Ahlers (SF-21-00005)

I am in receipt of a Notice of Application for a 25,652 square foot building pad for John and Lynn Ahlers.

I am providing comments as an owner of an adjoining piece of property.

RECORD OF SURVEY
KITITAS COUNTY TAX PARCEL NO. 080836
LOT 4, GRM SHORT PLAT NO. 1
FOR
JOHN & LYNN AHLERS

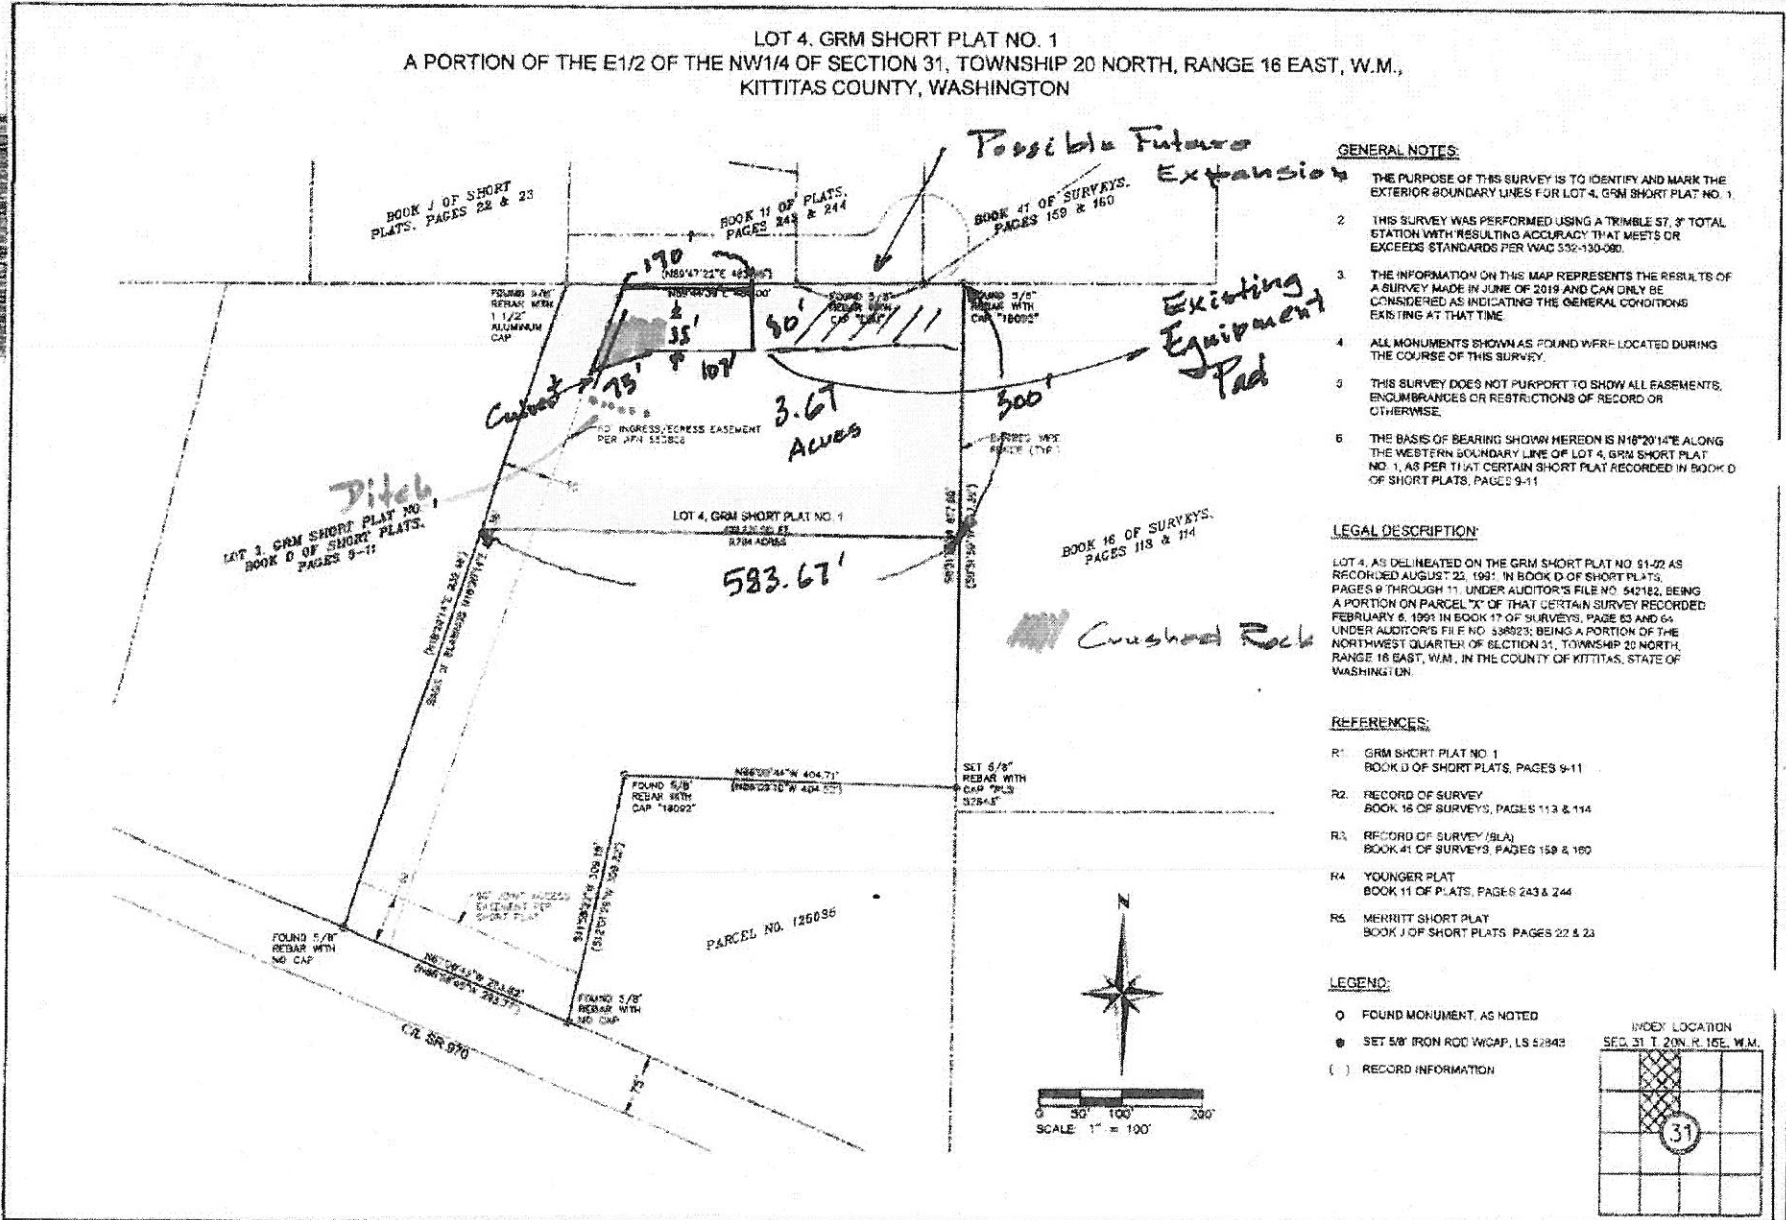
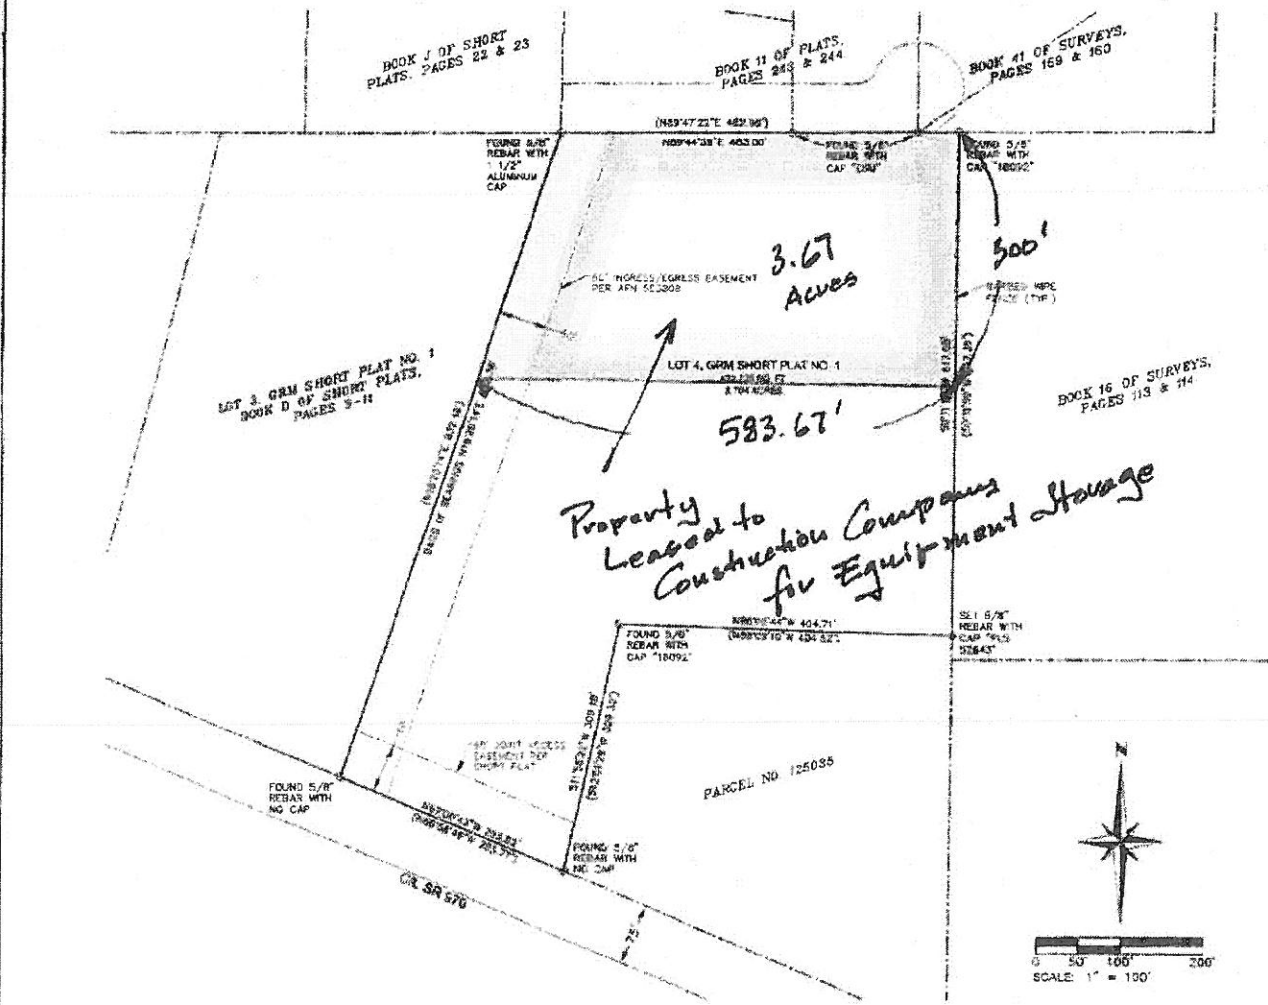
I am in receipt of Mr. Ahlers grading permit application. He states that the fill brought in was less than 500 cu yards based on a mathematical worksheet he provided. He also provided a map with dimensions showing the size of the floodplain area that was filled, 170' x 80'; exhibit A. Based on the worksheet he provided, he states 262 cubic yards of fill, based on 170' x 80' area with an average .5' of pit run fill and an average of 1.5' of gravel fill (per his notes) would equate to 938 +/- cubic yards of fill; exhibit B. Based on Kittitas County Department of Public Works Clearing and Grading Ordinance Exemption Flowchart, this amount of fill requires an engineered grading permit and a SEPA review, exhibit C. I do not see any record of an engineered grading permit or SEPA review in this application.

It is concerning to me that my and my neighboring properties are being jeopardized. This entire issue and all future liabilities could simply be remedied by moving this proposed slab south just out of the flood plain. That area is higher and is removed from the floodplain, thus not allowing future flood water to be displaced onto the neighboring properties to the north.

I urge the County to deny the application for this storage platform inside the flood zone and recommend it be moved south outside the flood zone to protect the public from any future mishandling of the flood zone.
